03 November 2021

Re: Hitchcock Road Quarry MOD1 – Response to Request for Information

Figure 7: Final Landform (Strategy B)

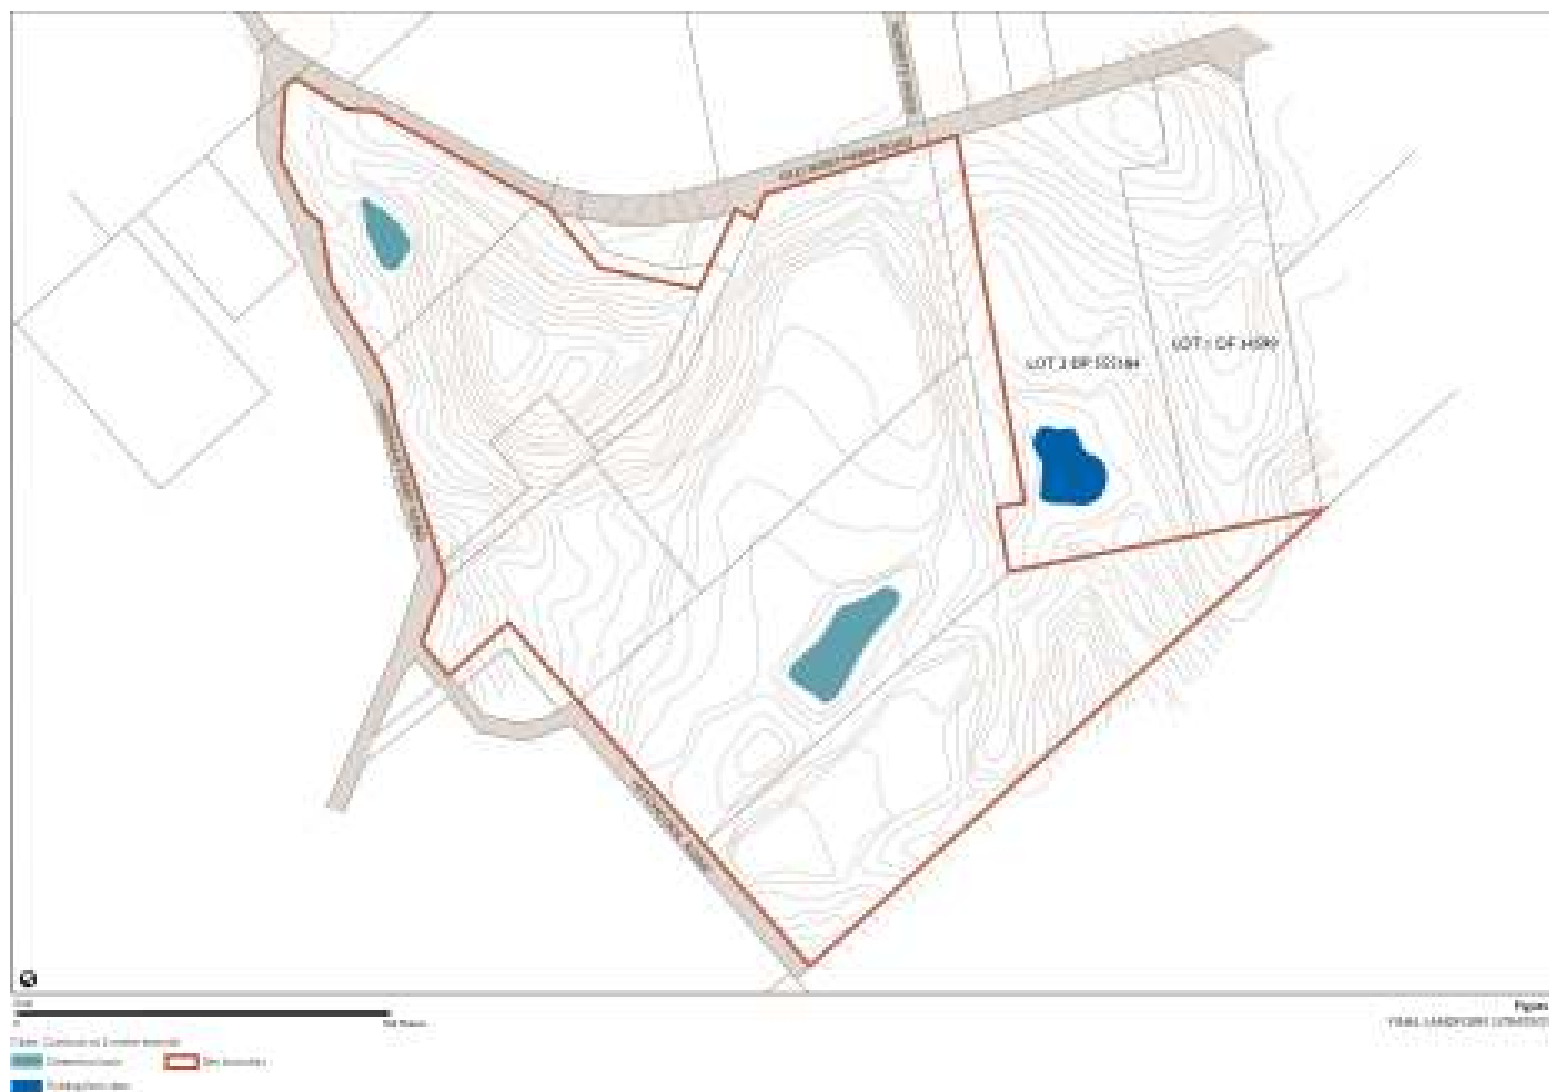
The final landform strategy that has been adopted for the Quarry is Strategy A. The Strategy B final landform was included within the current Project Approval 06_0104 as an alternative landform in the event that the proposed revegetation for biodiversity offsetting was unable to be successfully implemented. However, in accordance with *Schedule 2 Condition 10*, the Department confirmed satisfaction of the revegetation requirement on 15 March 2013. As such, Strategy B is no longer relevant. Although not necessary, if desired, reference to Strategy B could now be removed from the Project Approval.

In relation to the proposed final landform under MOD1, this remains consistent with Strategy A. It is proposed that the small area of extraction within the 10m buffer zone with Lot 2 would be backfilled similarly to the adjacent extraction area and provide a landform generally consistent with the currently approved Strategy A final landform. Subject to approval, a revised Landscape Management Plan will be prepared to reflect the backfilling of this area.
